**Consultation Response from Alan Smith,  
KC Waste Strategy (Refuse & Recycling)**

**2025/93514 land at, Brownhill Farm, Old Lane, Birkenshaw, BD11 2JL**

**Demolition of existing barns and erection of 4 detached dwellings**

**Date Responded: 17/02/2026**

Project	Proposed residential development at Brown Hill Farm, Old Lane, Birkenshaw BD11 2JL	
Client	Broadleaf Properties Management Ltd, 21 Clare Road Halifax West Yorkshire HX1 2HX	
Dwg Title	(25419)3_Site Plan	A
Scale	1:200 @ A1	
Date	Aug 2025

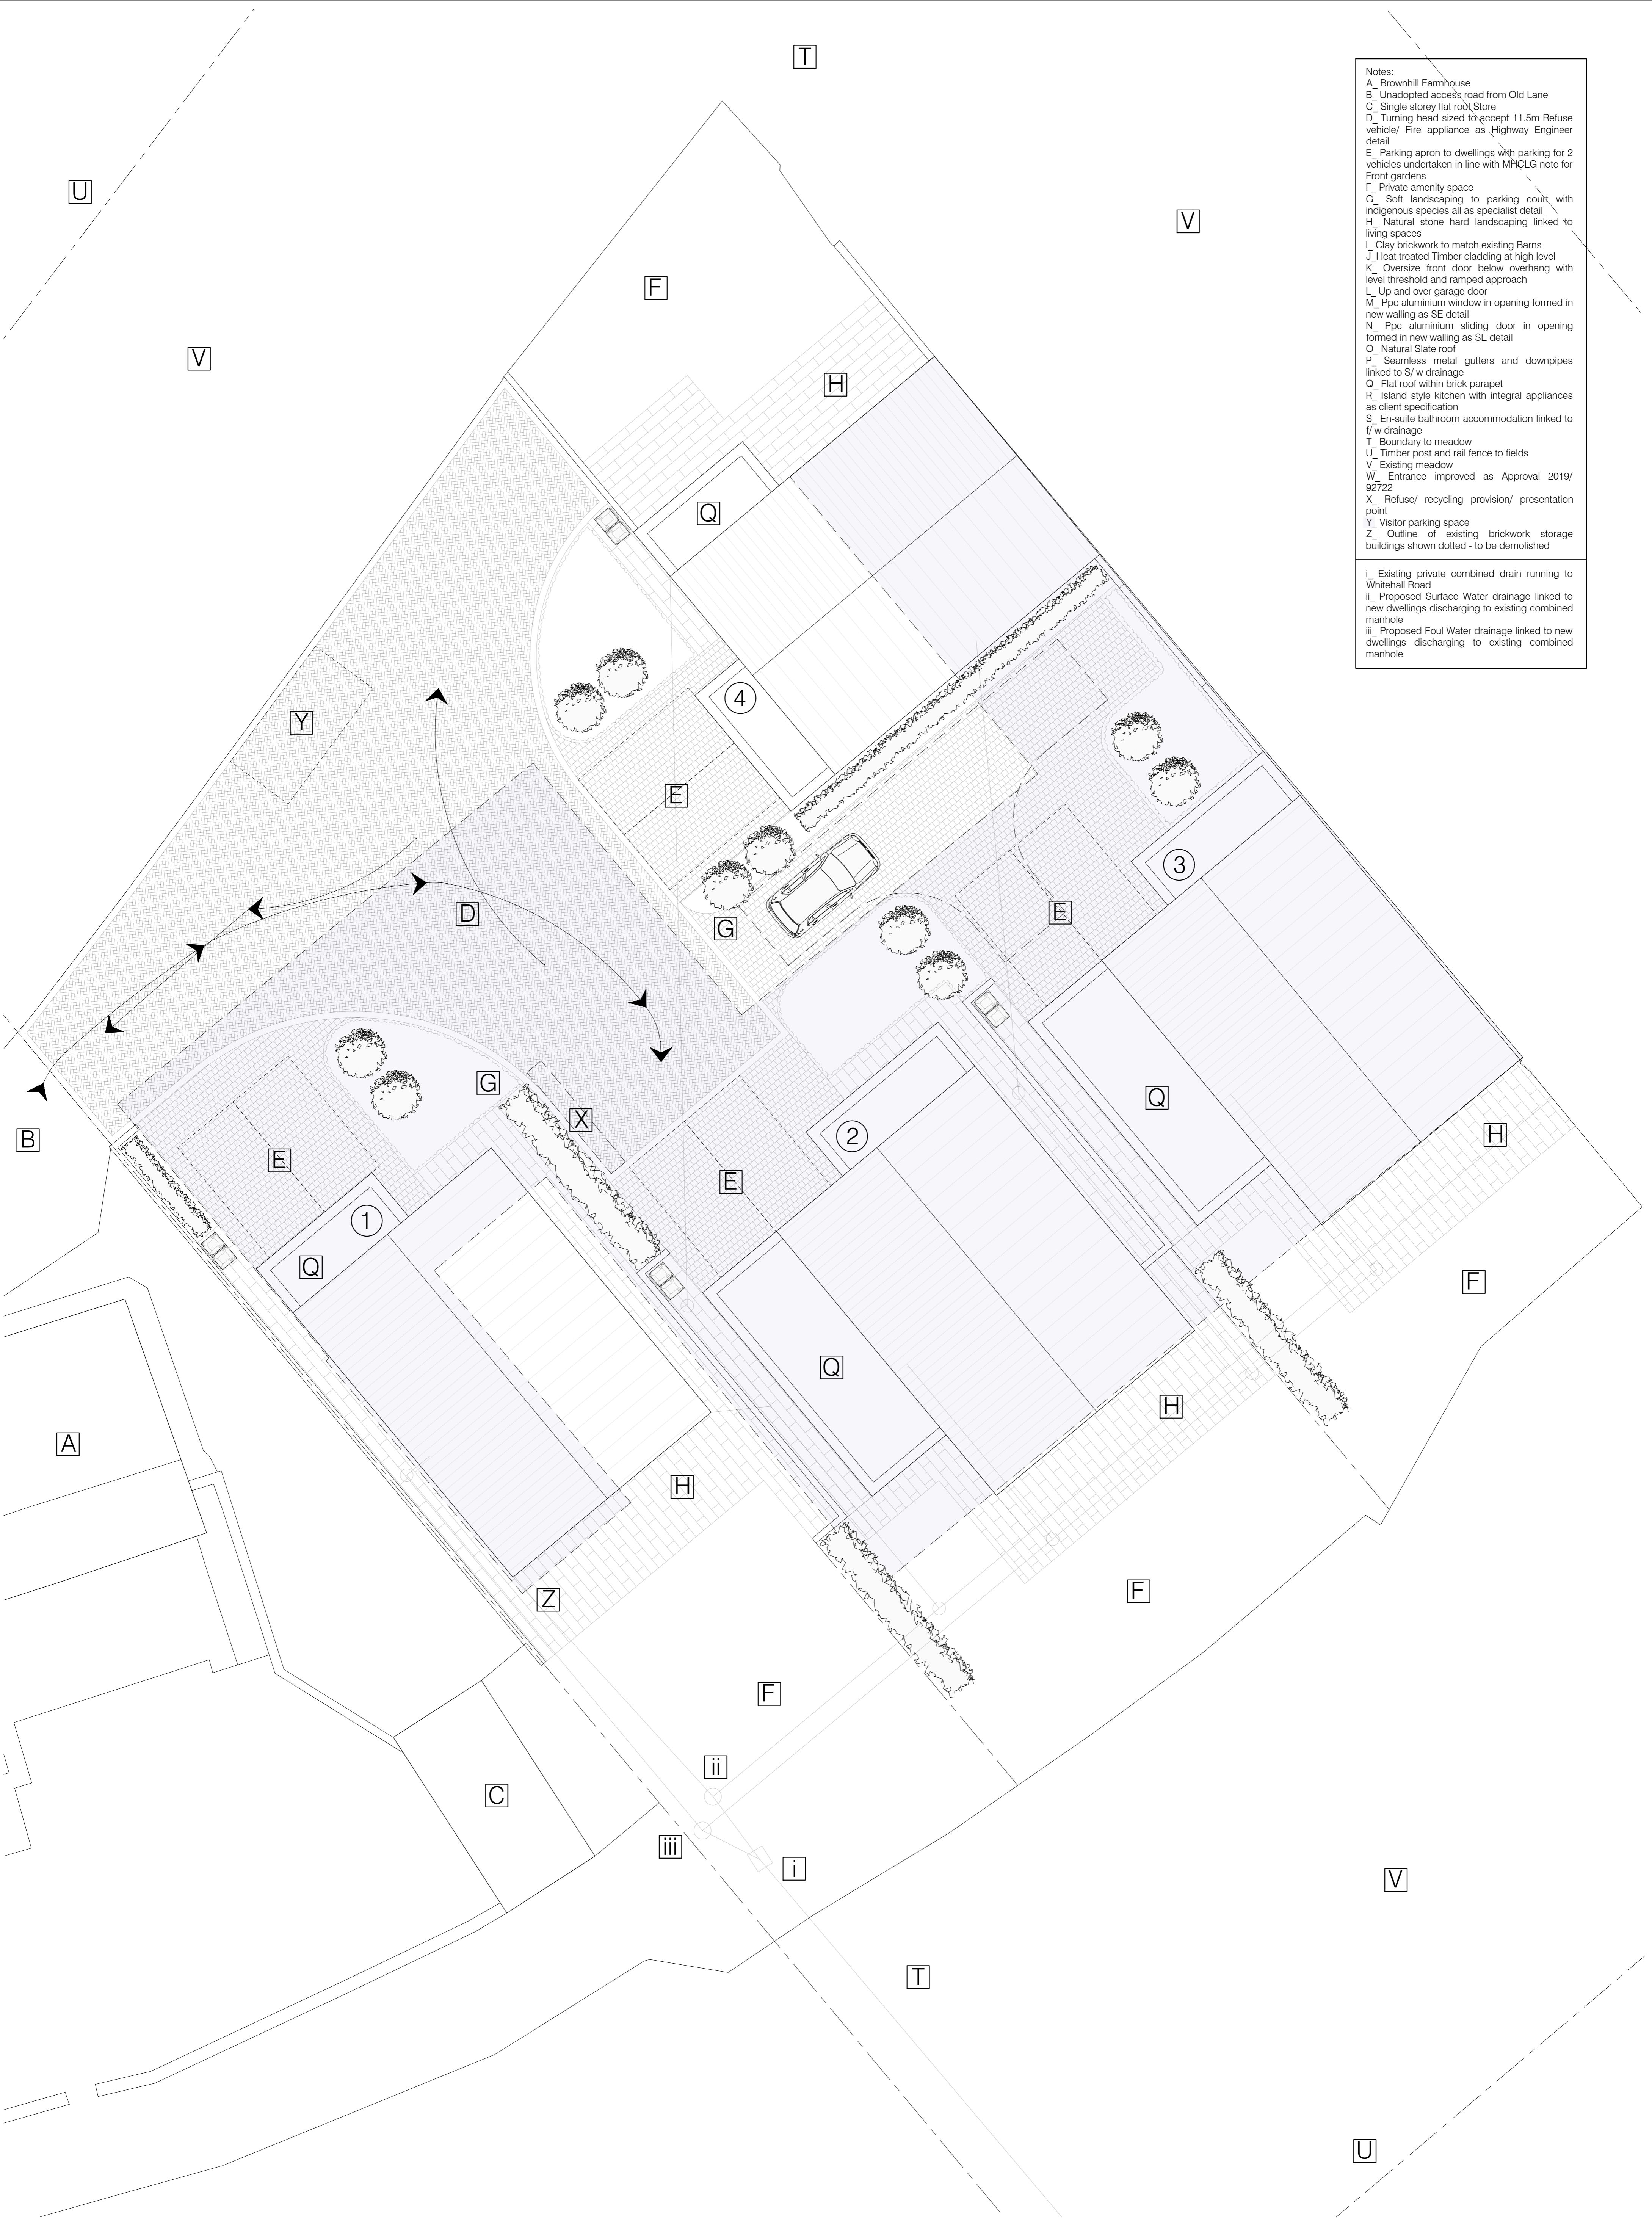
- The BCP for these properties will be adjacent to Old Lane
- Located adjacent to an adoptable highway
- Solid surface required, resistant to constant wear and tear

- Temporary BCPs may be needed for early occupiers whilst site is being built (likely collection area would be adjacent to Old Lane)

- The WCA will not enter:
  - Private drives
  - Roads not built to an adoptable standard
  - Active construction sites
- Reversing distance for an RCV must not exceed 12 m (WISH guidance)
